Our Case Number: ACP-324584-26

Re: Proposed Limerick Wastewater Treatment Plant Upgrade & Regional Bioresource Centre
off Dock Road, Ballykeeffe, Corkanree and Courtbrack (townlands), Limerick

O.P.W Ref No. 227-2026

Re: Case Number: ACP-323900-25, Proposed upgrades to Limerick Wastewater Treatment Plant and Regional Bioresource Centre, Bunlicky, County Limerick.

CORCANREE PS
- EXISTING SITE LAYOUT PLAN

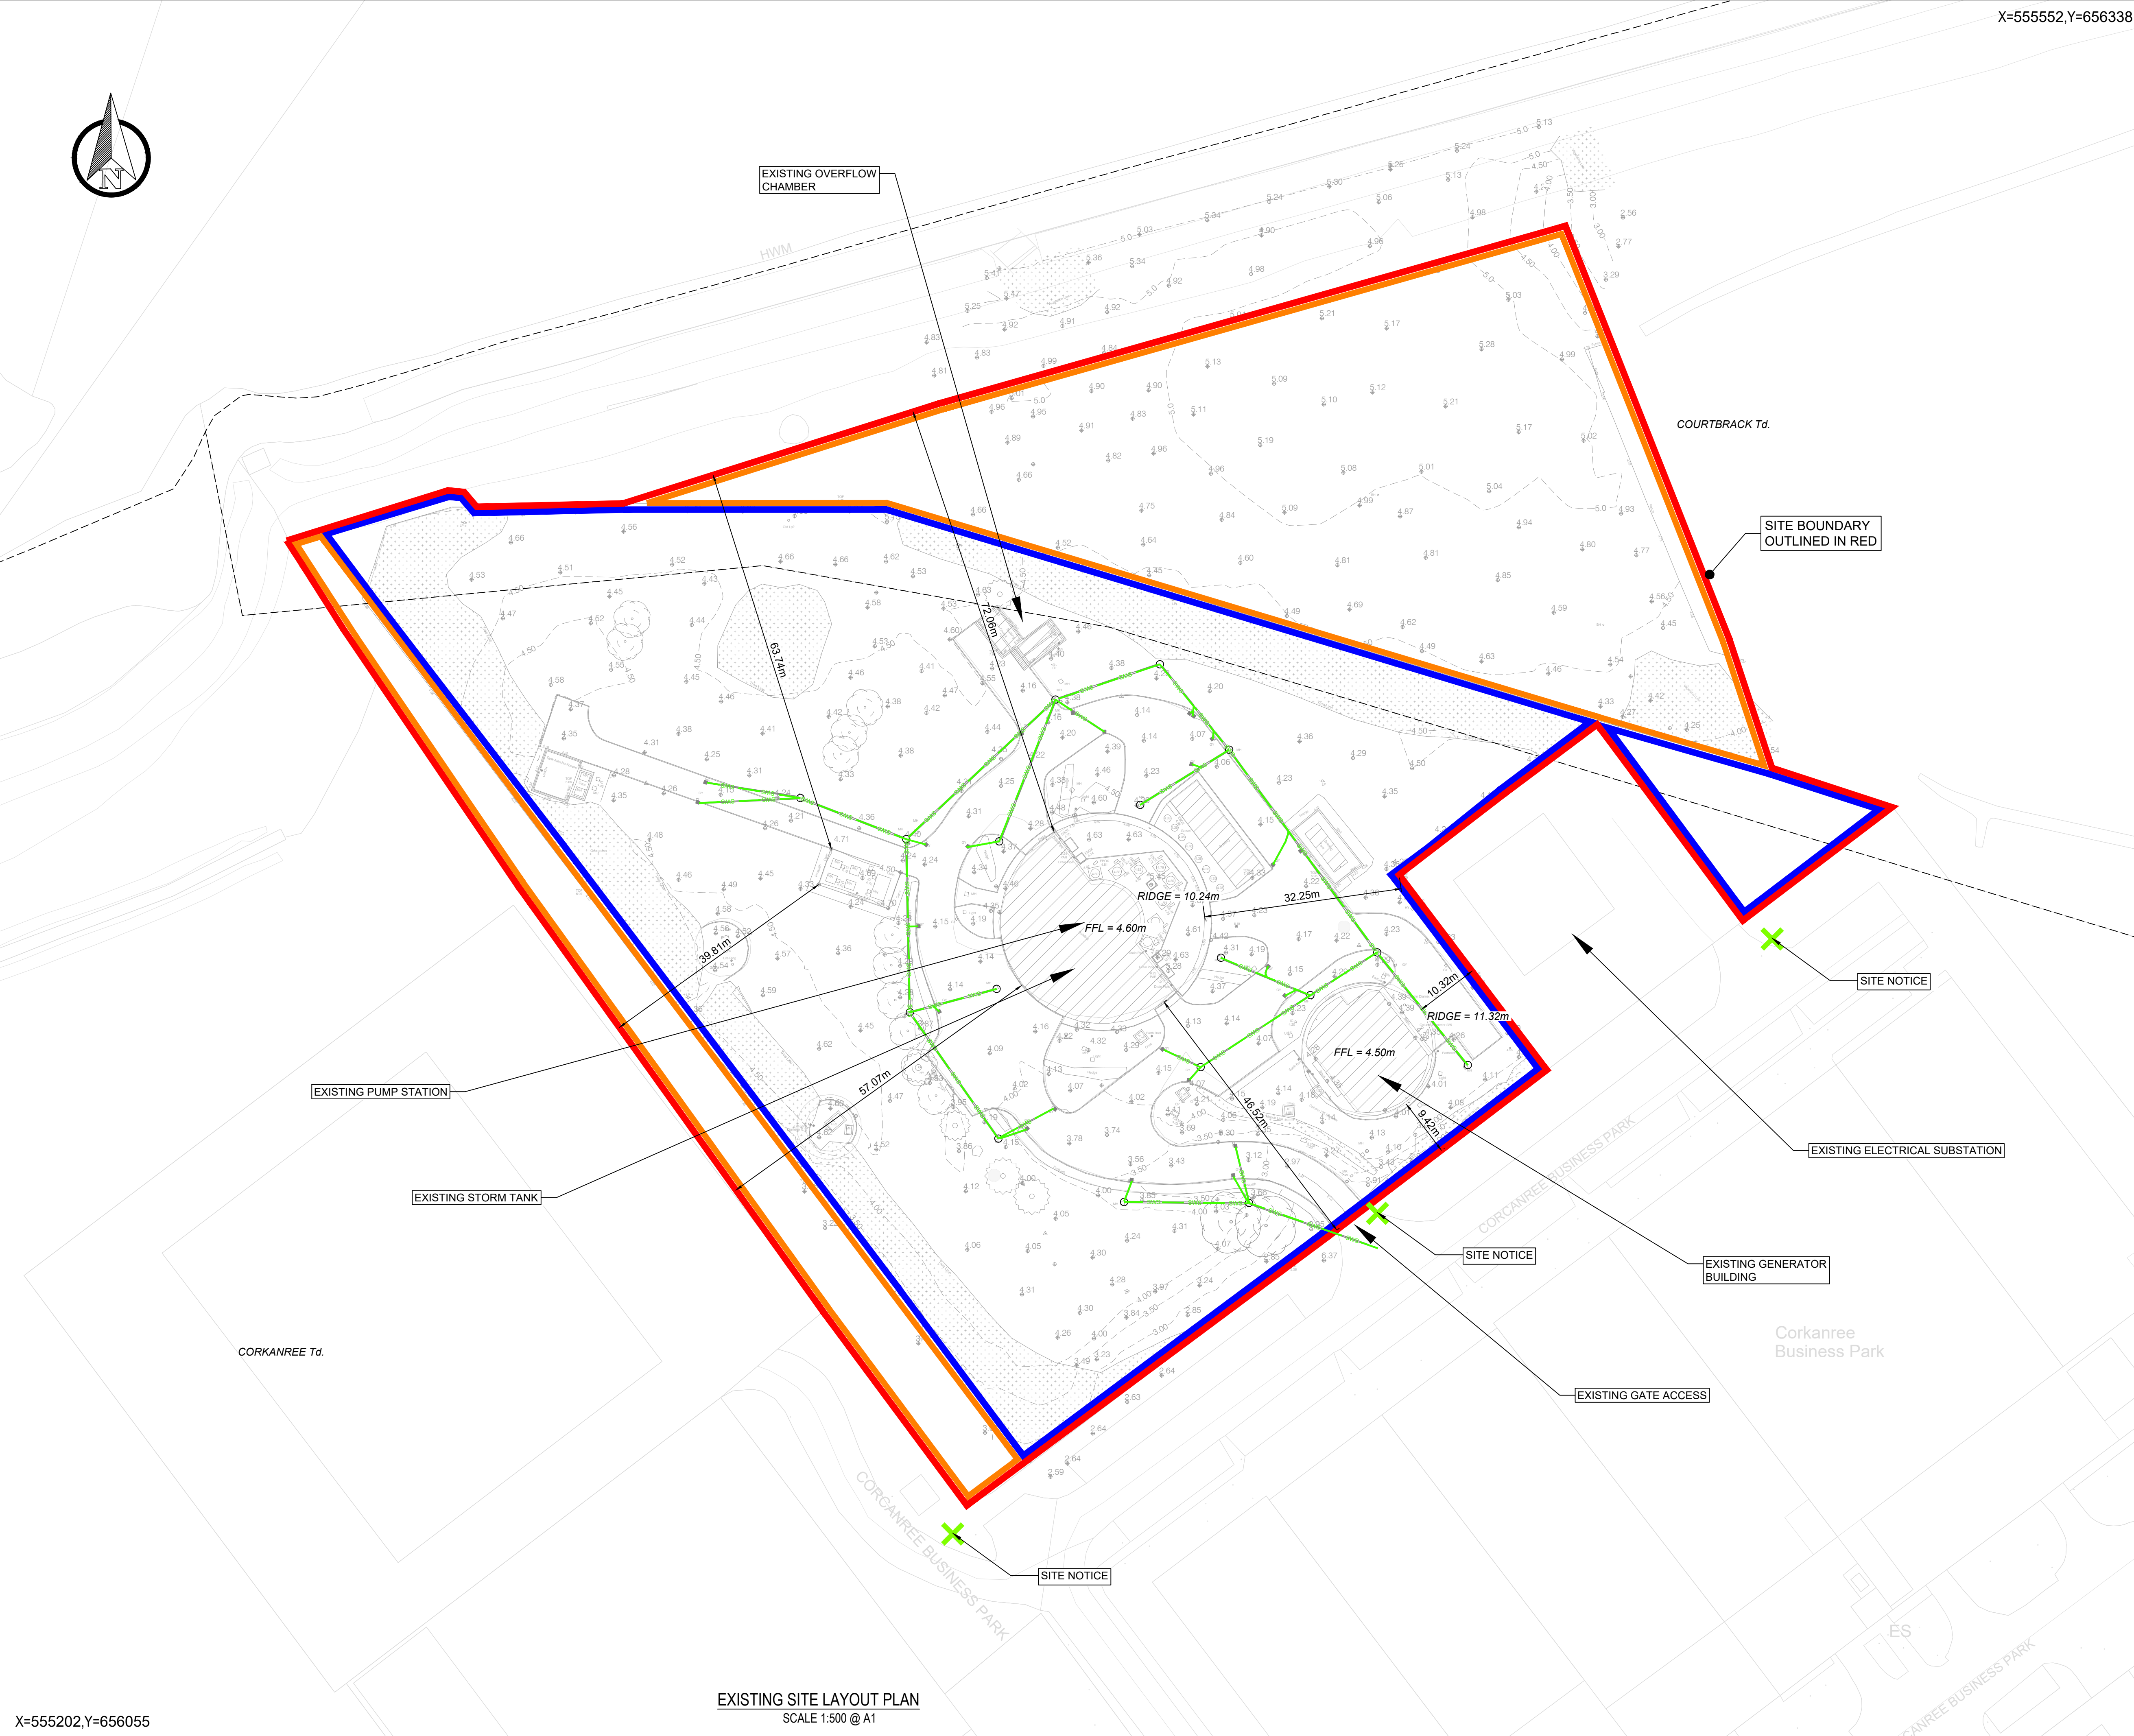
The site on Map A which contains Corcanree Pumping station is bounded on the Northern side by OPW Channel D1 of the Polefield Arterial Drainage Scheme which is under the auspices of this office. In order to gain access for the purpose of maintaining this channel, the Office of Public Works requests that the following be included as a Condition of any Grant of Planning Permission.

This office would request that a 5 Metres Wide strip be retained, adjacent to the channel D1 to facilitate on-going access and maintenance requirements. This strip should be unimpeded to mechanical plant and should not be landscaped, paved or otherwise developed in a manner that would impede or prevent access to said channel.
